Approval of details reserved by condition imposed under FG/69/16/OUT
(APP/C3810/W/17/3166634) relating to condition 6-proposed traffic light system.

Paddock House 44 Ferringham Lane Ferromg

Thank you for your internet representation made on 26th April 2018 which has been recorded as '**an objection**' with the comments as follows:

FG/ 43/ 18 /DOC

Build Specifications

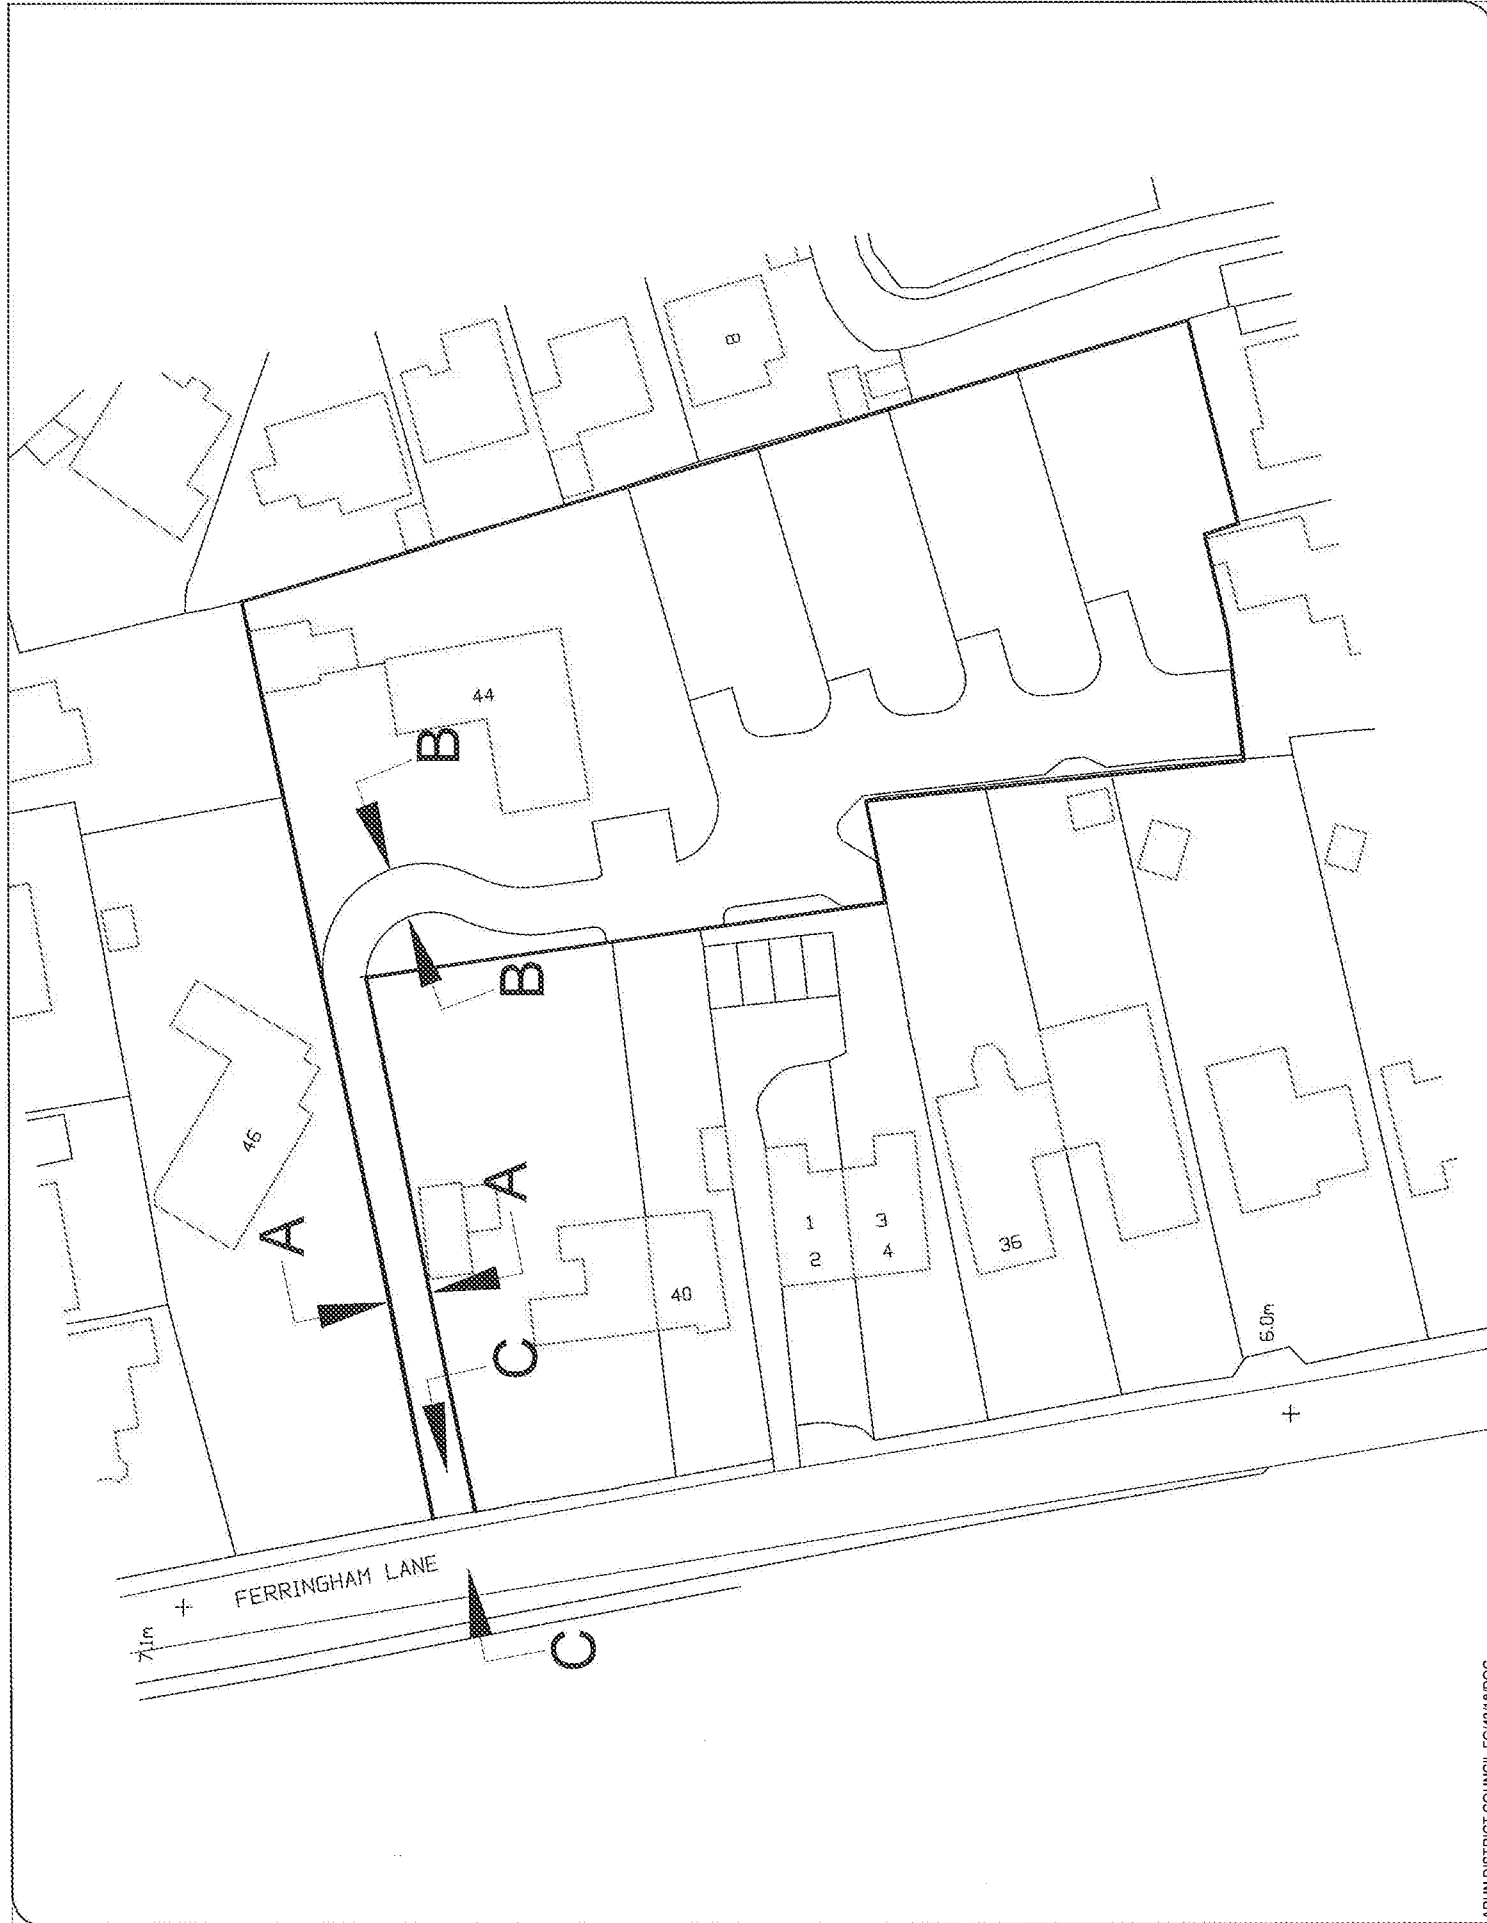
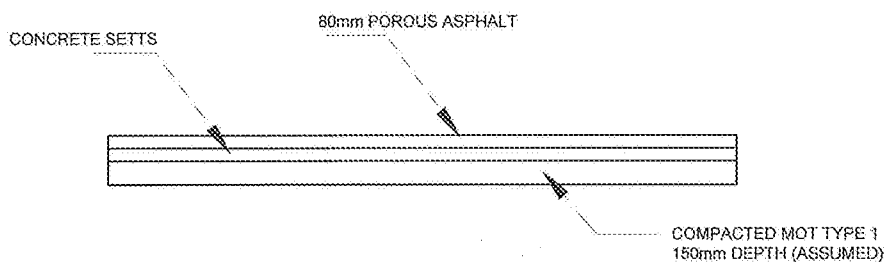
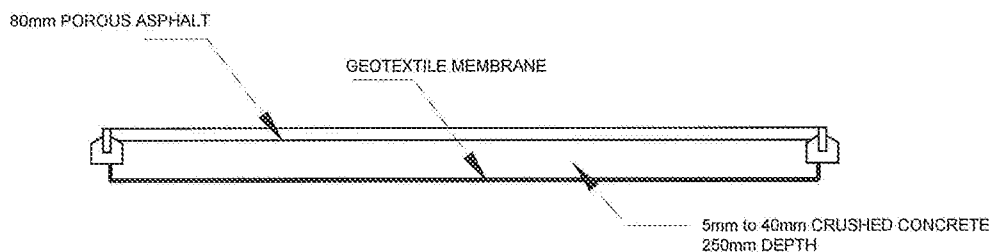
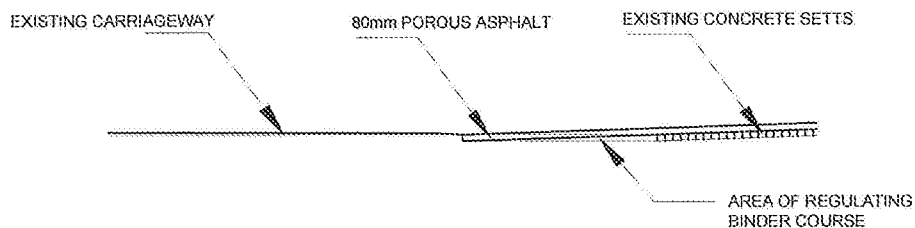
The plans submitted are incomplete. Neither show the measurements required by the inspectorate, nor the configuration of the mandatory splay, or a detailed illustration of the positioning of any light system at the entrance. Furthermore the requirement of a regular maintenance schedule for the light system is also not included.

Similarly Reeves Transport can still only allude to a 4m width driveway at this time on the basis of an ongoing "boundary" dispute with the adjacent property.

Note: Various officials have since measured the current access width to date, a maximum of 3.65m recorded, not one has measured 4m.?
